Subject: RE: Wandleys Farm 11117 Planning Consultation on: WA/21/21/DOC

Application No: WA/21/21/DOC
Registered: 15th March 2021
Site Address: Wandleys Farm Wandleys Lane Walberton BN18 0QR
Description of Works: Approval of details reserved by condition imposed under ref APP/C3810/W/18/3209249 (WA/76/17/PL) relating to Condition Nos 3 - materials & finishes, 4 - surface water drainage, 5 - Written Scheme of Investigation, 7 - hard & soft landscaping and 8 - Construction Method Statement

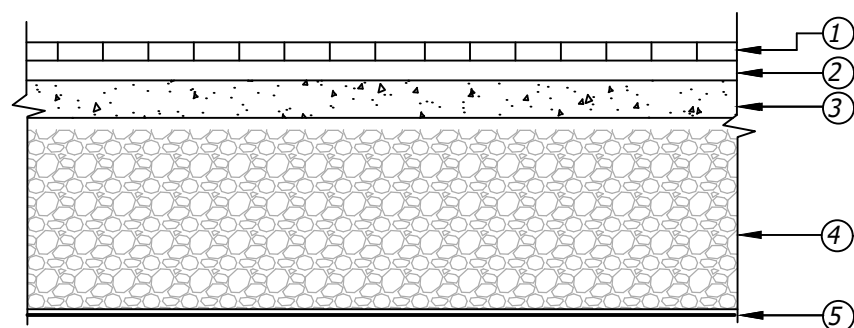
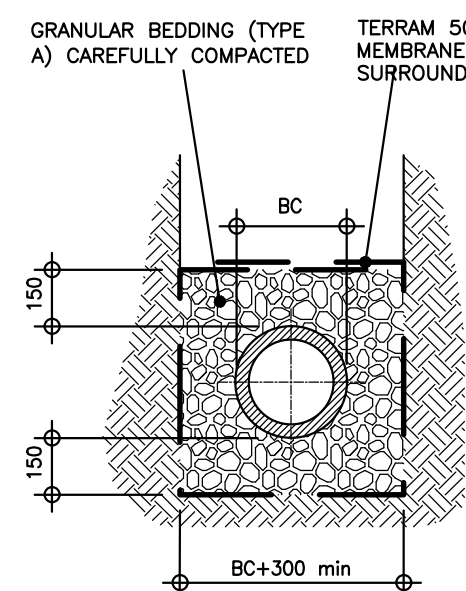
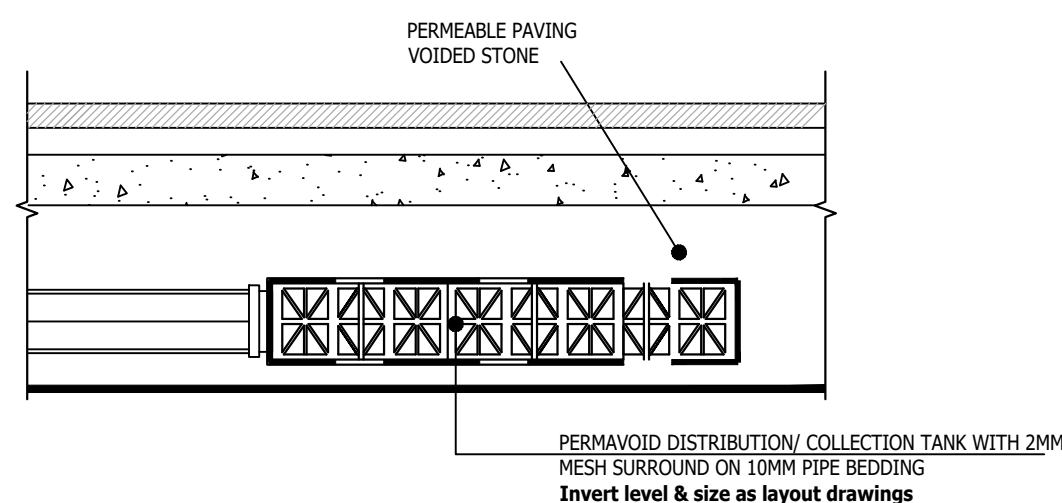
- a. ~~Pipe bed and surround~~ Done
- b. Permeable paving including diffuser blocks. – This needs to be altered to have an impermeable liner wrapped around the bottom and side, and a permeable membrane between course 3 and 4 (due to high groundwater)

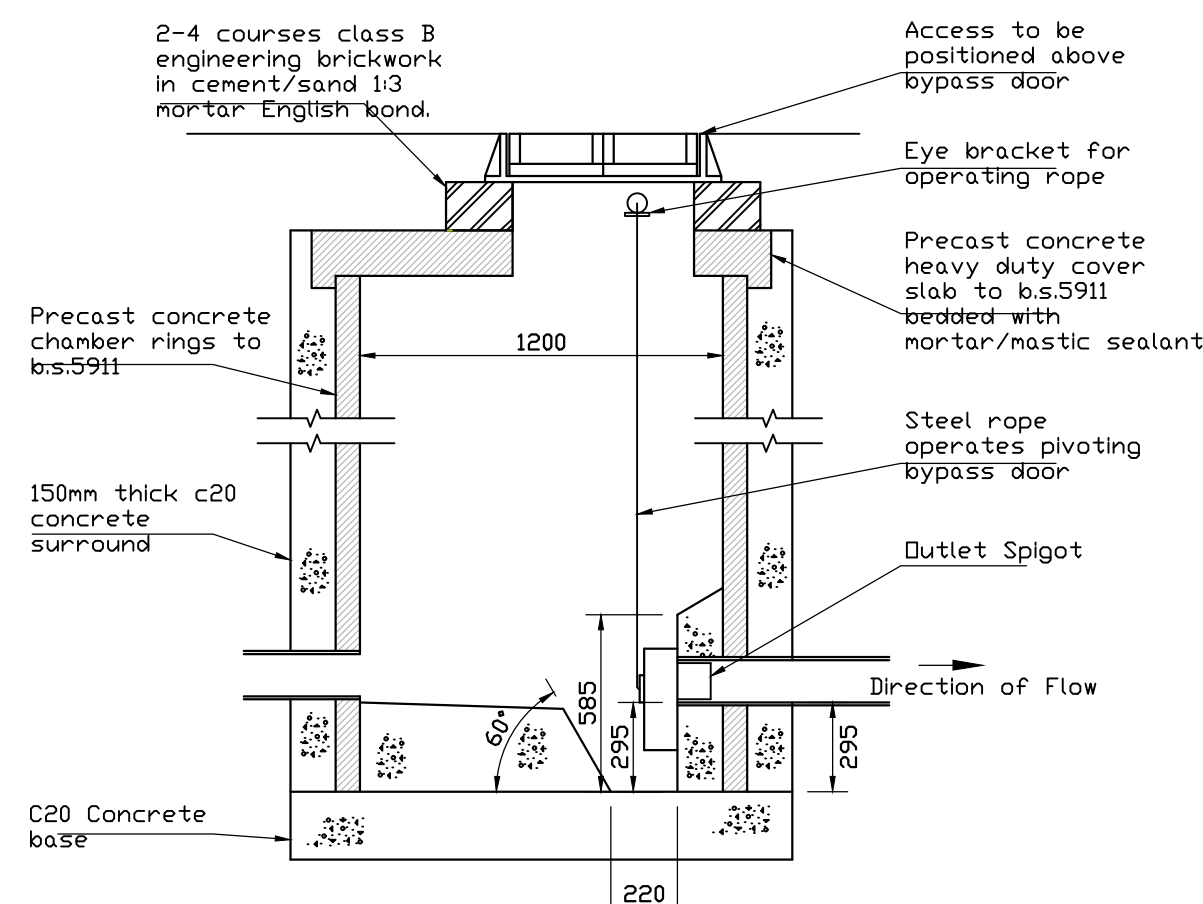
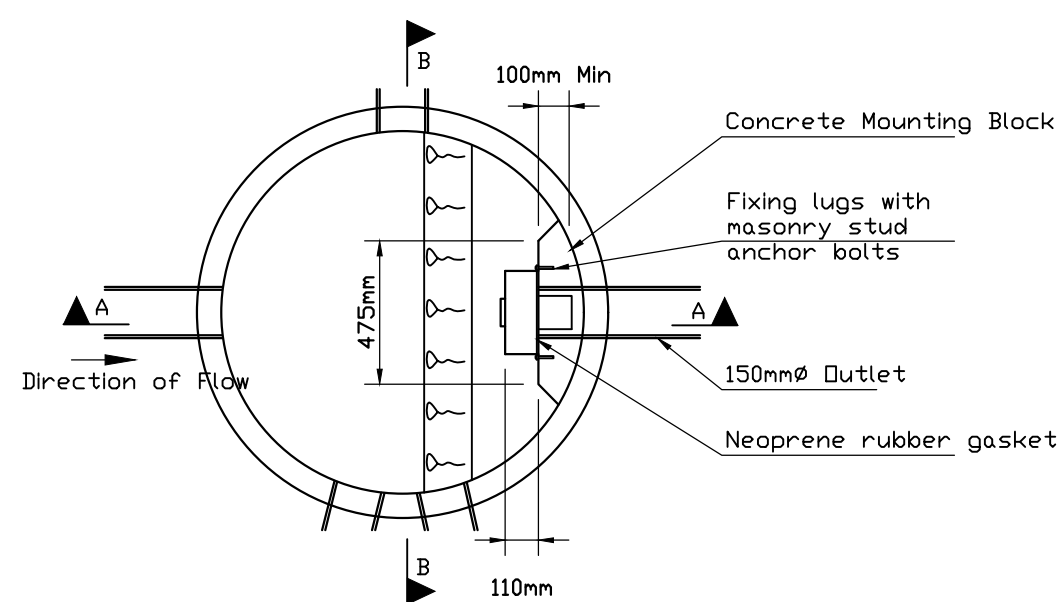
- d. Both different hydrobrakes, in accordance with the calculations. One Hydrobrake detail has been provided, if the differences between the two used on site are minor I am happy for these to be tabulated alongside the detail. If not please provide both details as these should be site specific.

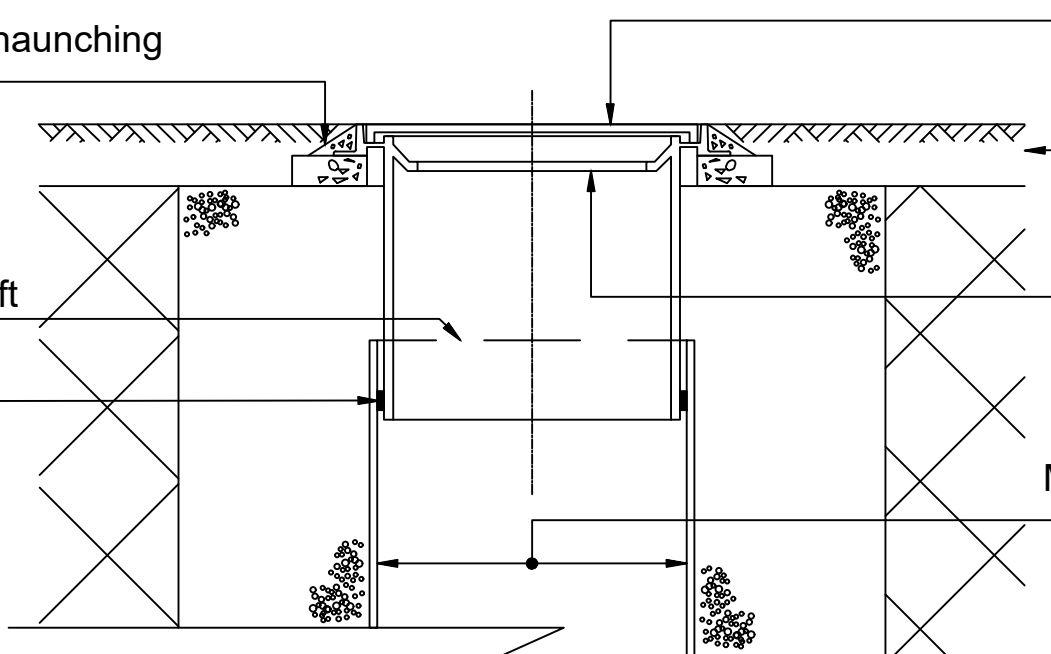
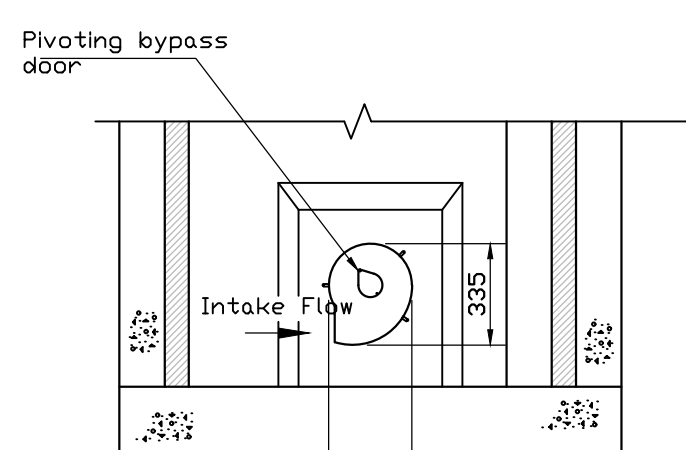
- c. Manholes/inspection chambers/silt traps An access chamber detail has been provided with no base included. I need to see two different chambers, one with a catchpit/sump and one without as per the drainage layout.

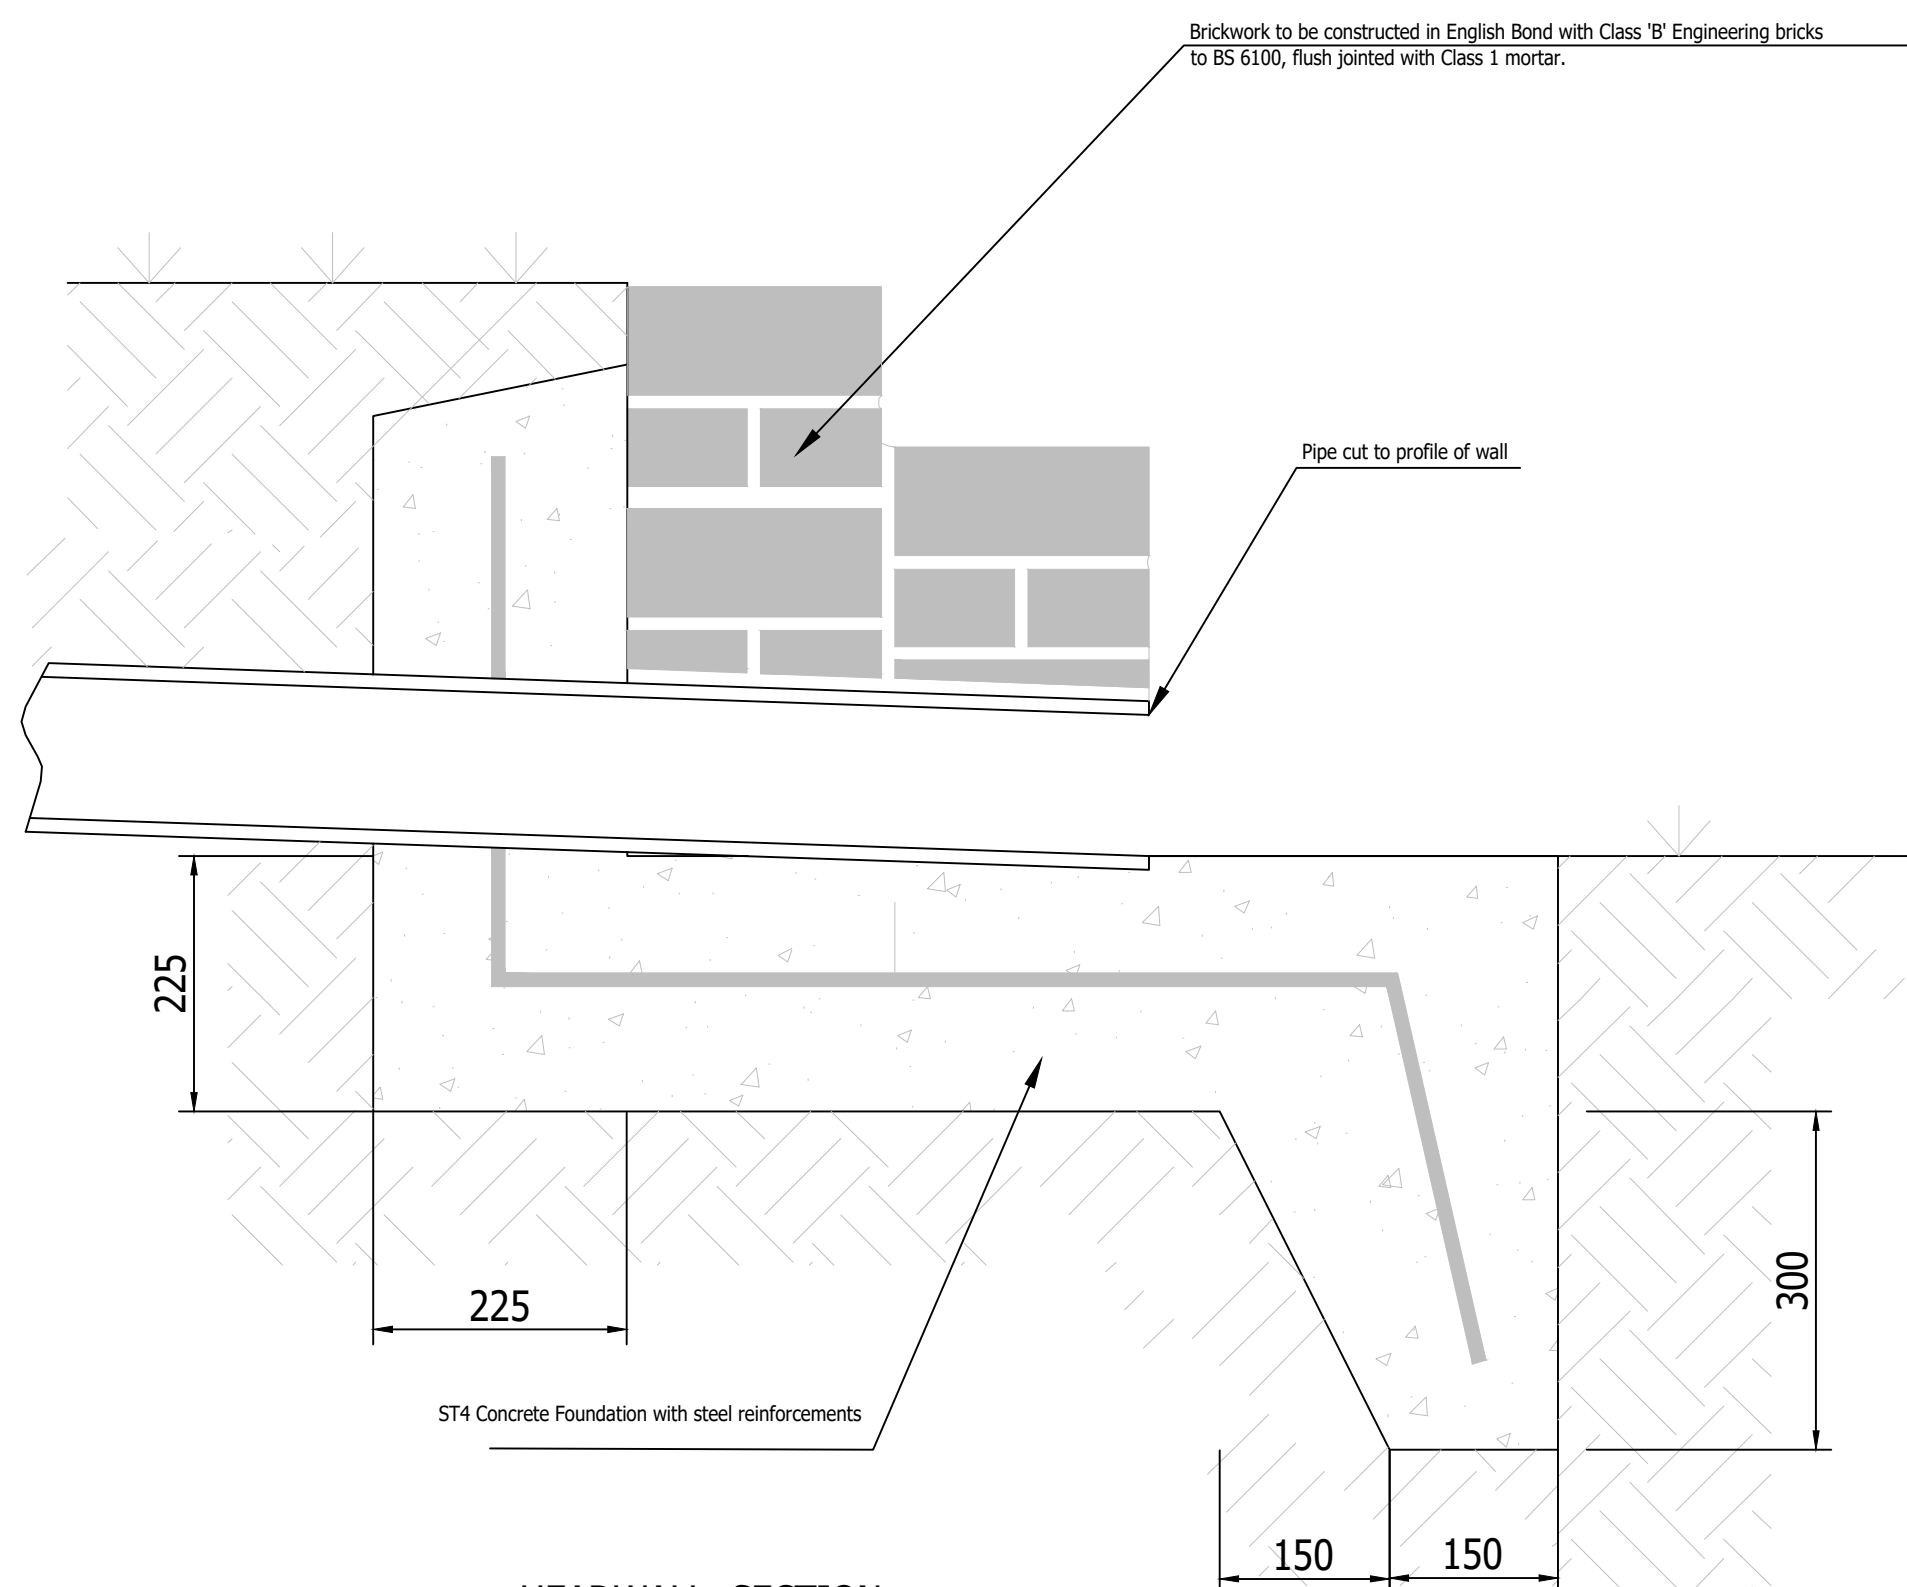
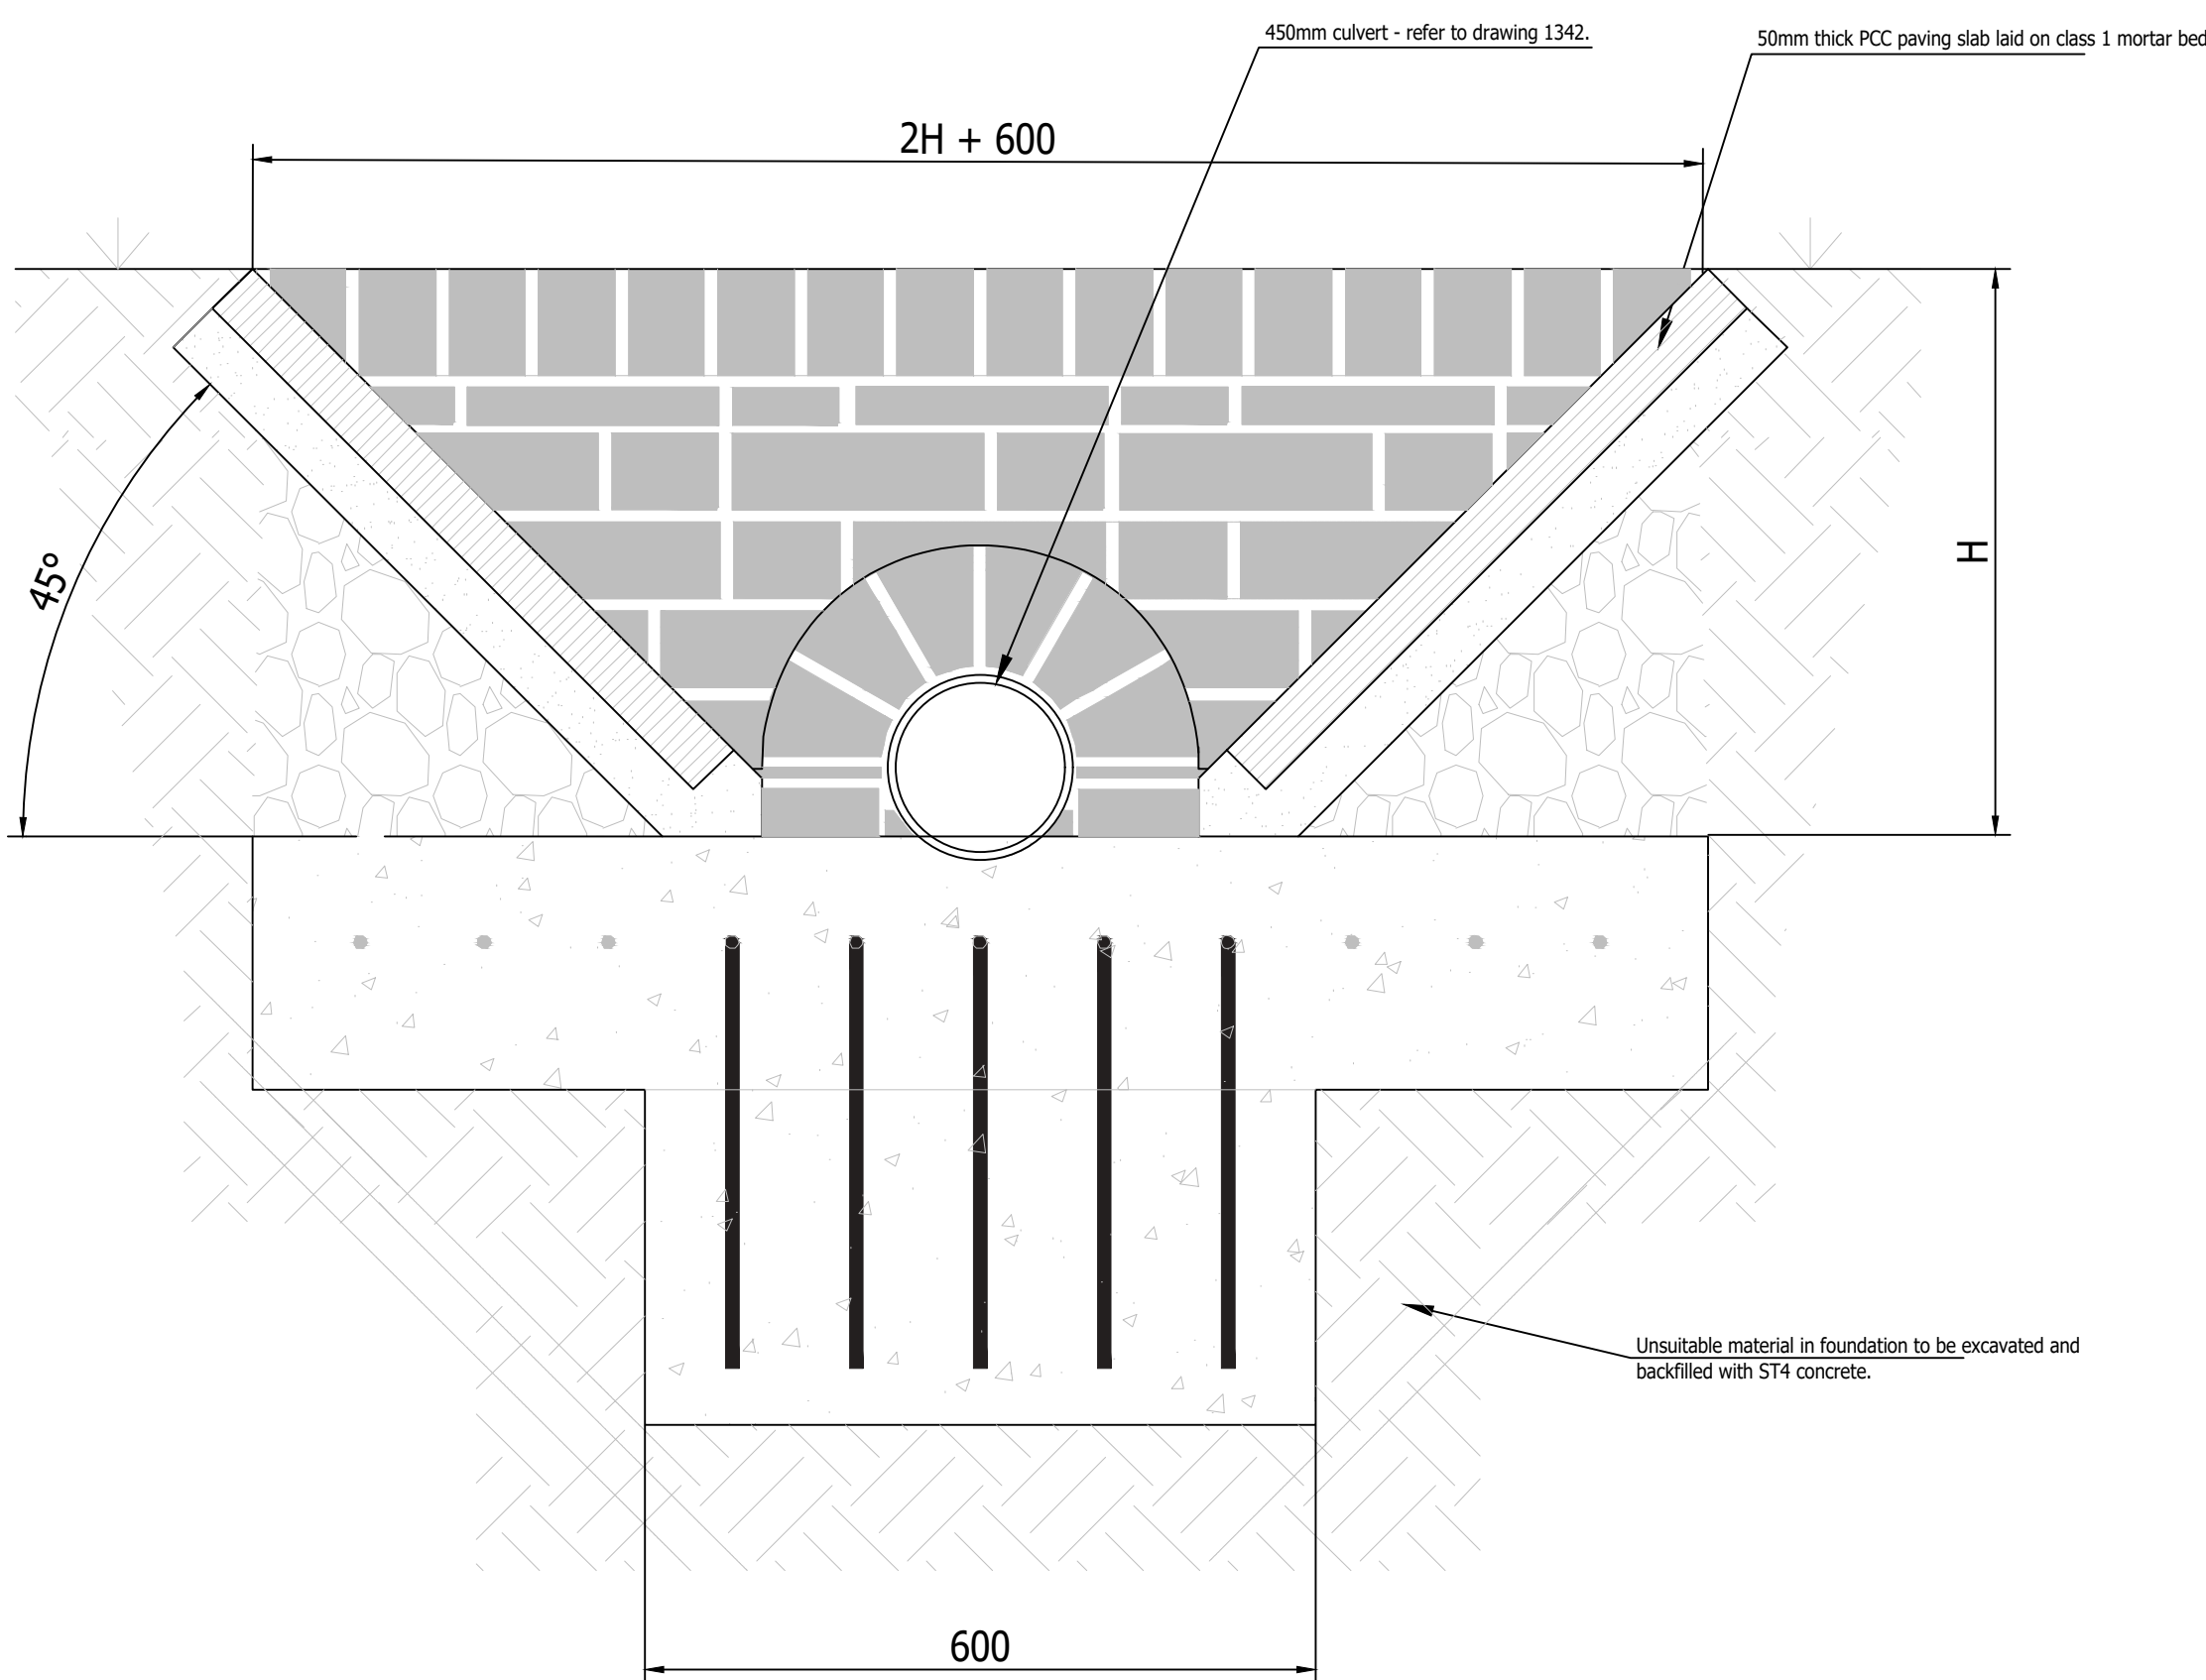
- e. Headwall to the watercourse – As discussed, remove the brick headwall from sheet 1103 and submit sheet 1341 alongside the other construction details as this is what Paul is basing the LDC upon. This will free up space for the adjustments listed above.
